The Planning Inspectorate
Temple Quay House
Temple Quay
Bristol
Avon
BS1 6PN

Our ref: KT/2016/121281/01
Your ref: EN020017
Registration ID: 10032057
Date: 8 July 2016

Application for the Richborough Connection Project comprising the installation of a 400kV electricity connection (overhead line) between Richborough and Canterbury, Kent.

Please find below our Written Representation for the Richborough Connection Project.

2D Proposed South East Water Reservoir - Route Options Appraisal

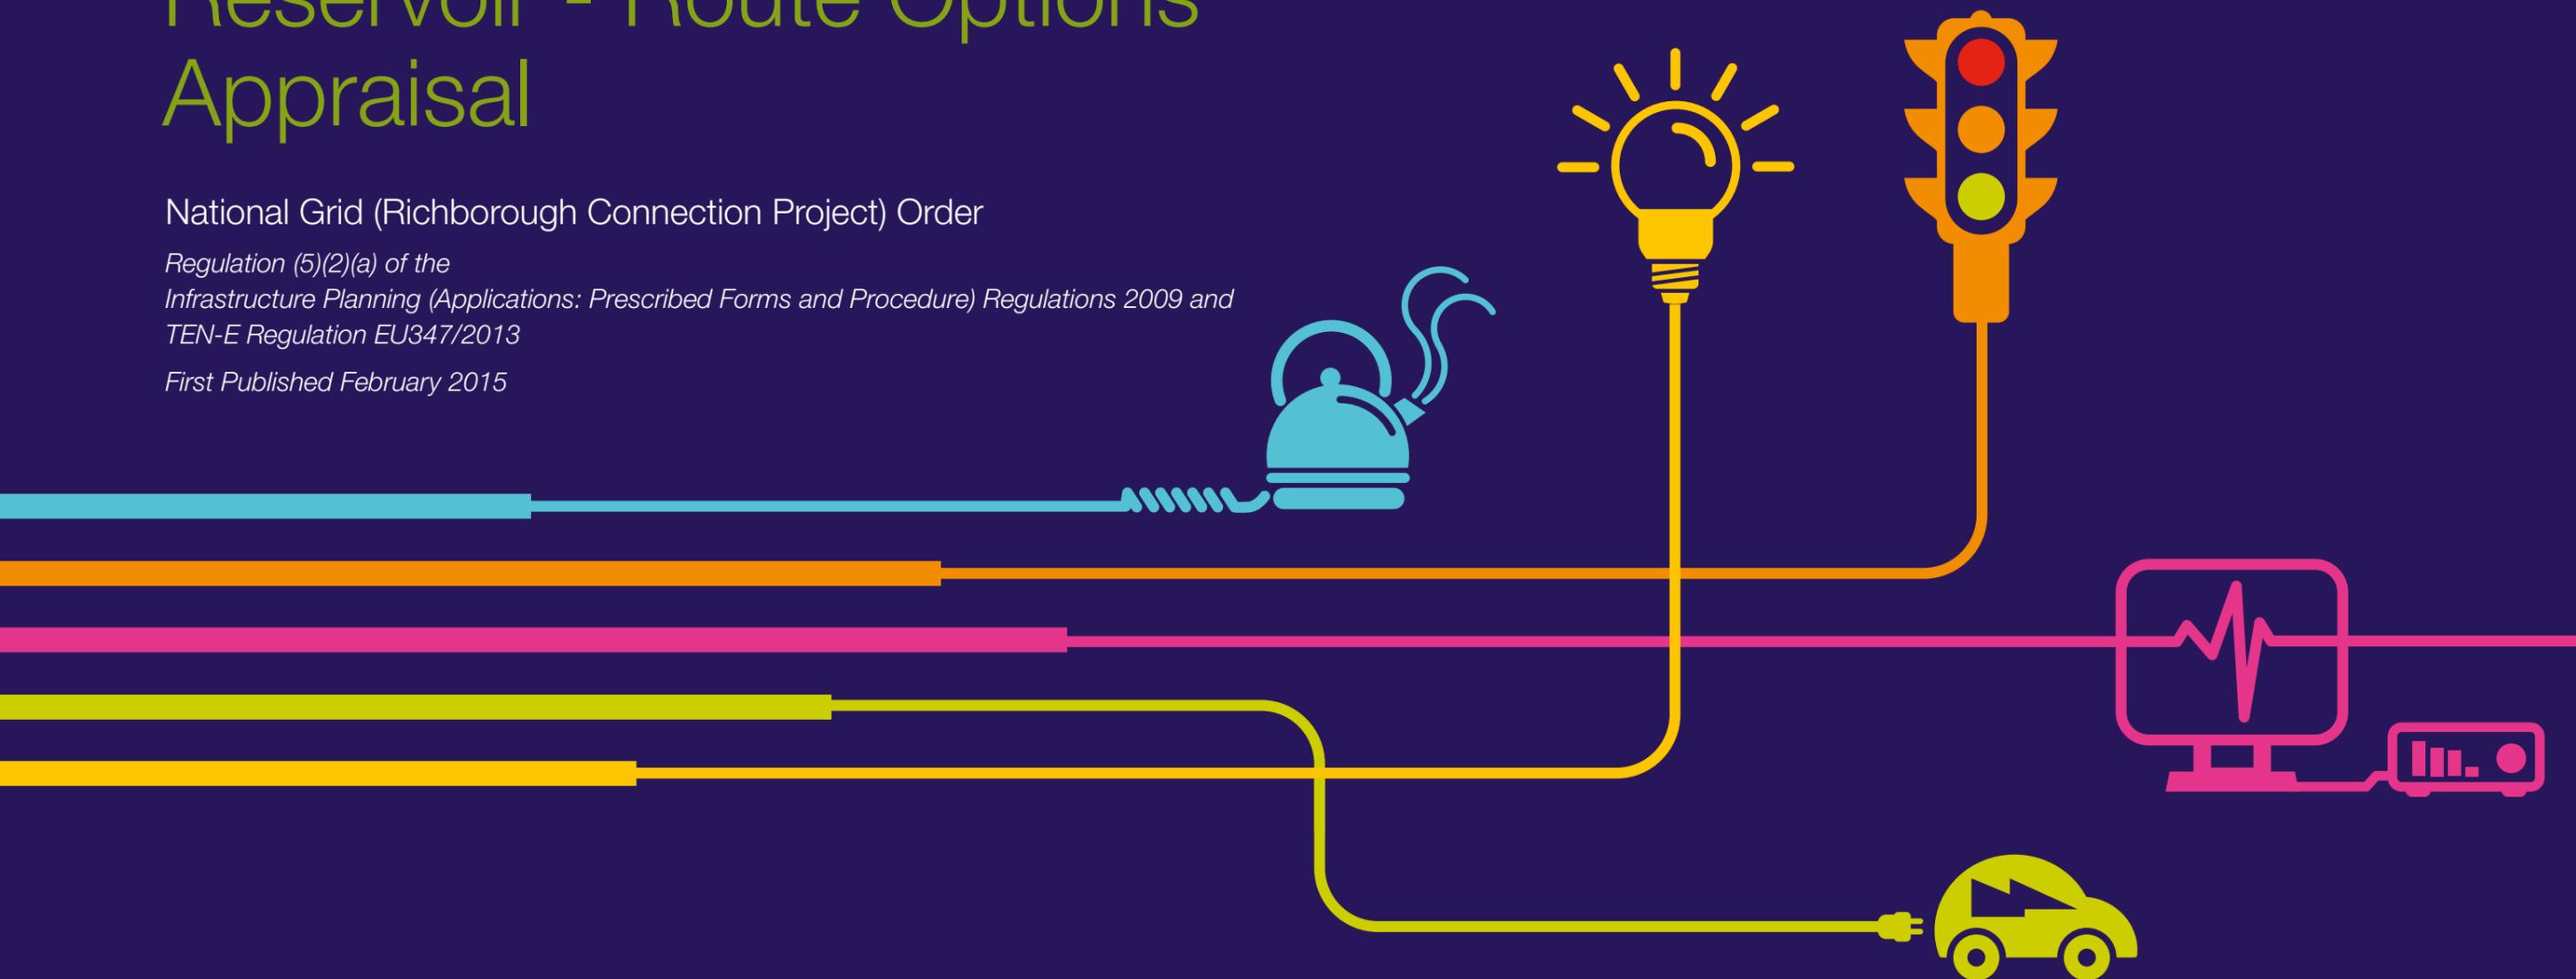
Construction of the Reservoir will require mitigation as the Sarre Penn (stream that runs through the site) will need to be realigned and be passable by fish. The submitted plans show that a section of the proposed route falls within the footprint of the Sarre Penn realignment.

Given the importance of this scheme to maintaining security of supply, we strongly advise National Grid to continue to work with South East Water to consider the implications of the proposed transmission route and the viability of Broad Oak Reservoir, specifically whether the Reservoir's existing designed mitigation measures remain feasible. The implication, should the Reservoir no longer be considered feasible, is that alternatives would need to be explored. These may be more costly, less sustainable, involve less proven technologies and take longer to implement. Alternatively, alterations may be required of the pylon route, which, once constructed, would be expensive.
